S278 AGREEMENT WORKS

MERAKI ALLIANCE: STAGE I ROAD SAFETY AUDIT.

RESPONSE DATE: 08.06.26

Date: APR 26  
 Scale: 1/200 @A0  
 Dwg No.: E25/8392/040A

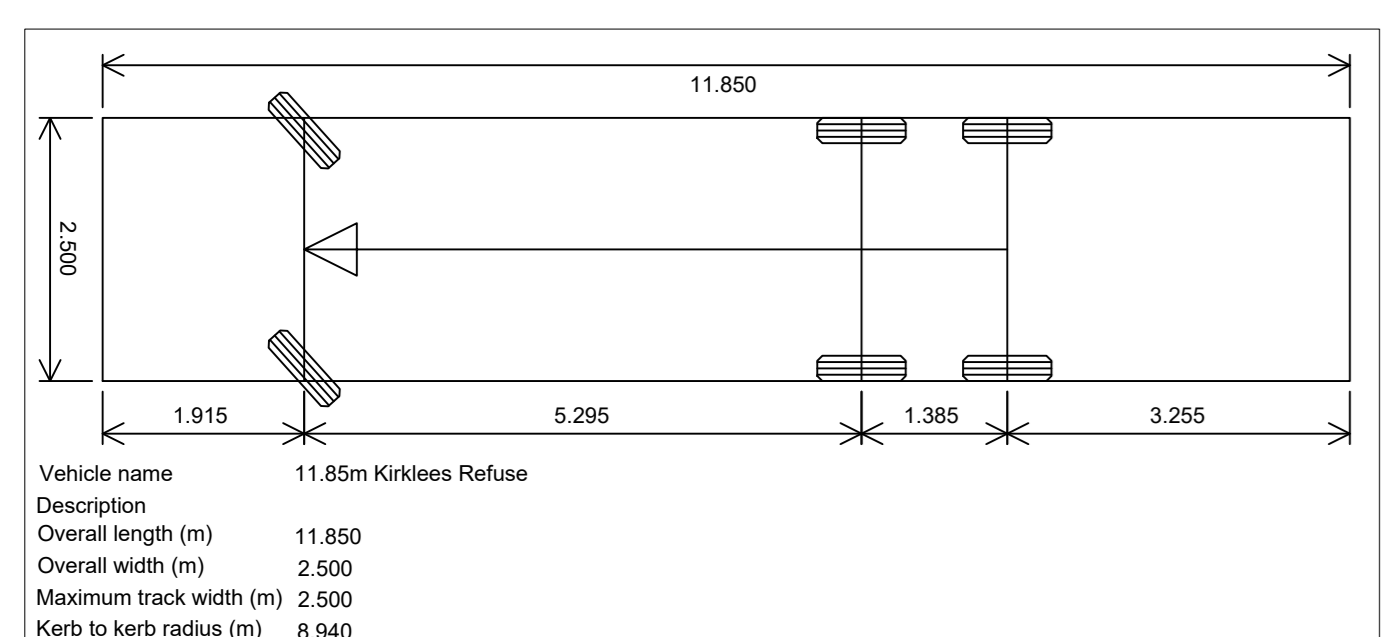
Ref	Repeat Stage 1 Road Safety Audit		Design Organisation response	Overseeing Organisation response	Agreed RSA action
	RSA Problem	RSA Recommendation			
2.1	Location: General to scheme Summary: Drivers could become confused if old road markings are not fully removed before the new markings are implemented	Ensure the existing carriageway markings are fully removed or that the carriageway is resurfaced.	Key added to dwg. 8392_040A to show existing road markings to be removed.	Although a drawing Key was added to dwg. 8392_040A it did not indicate road markings were to be removed and replaced with new appropriate markings, please add a note setting this out.	Amend dwg. 8392_040A as per the Overseeing Organisation Response.

Ref	Repeat Stage 1 Road Safety Audit		Design Organisation response	Overseeing Organisation response	Agreed RSA action
	RSA Problem	RSA Recommendation			
2.1	Location: Proposed development access Summary: Increase in cross path collisions or pedestrian collisions, due to obstructed visibility. 	Ensure that the visibility splay is achieved and is kept free of obstructions, in perpetuity by undertaking site clearance.	Dwg. 8392_040A shows 2.4m x 40m Visibility Splay achieved, with no obstructions.	The area within visibility splay indicates vegetation on the background topo survey information on Dwg. 8392_040A, please add a note on this drawing indicating that all obstructions including vegetation will be removed.	Amend dwg. 8392_040A as per the Overseeing Organisation Response.
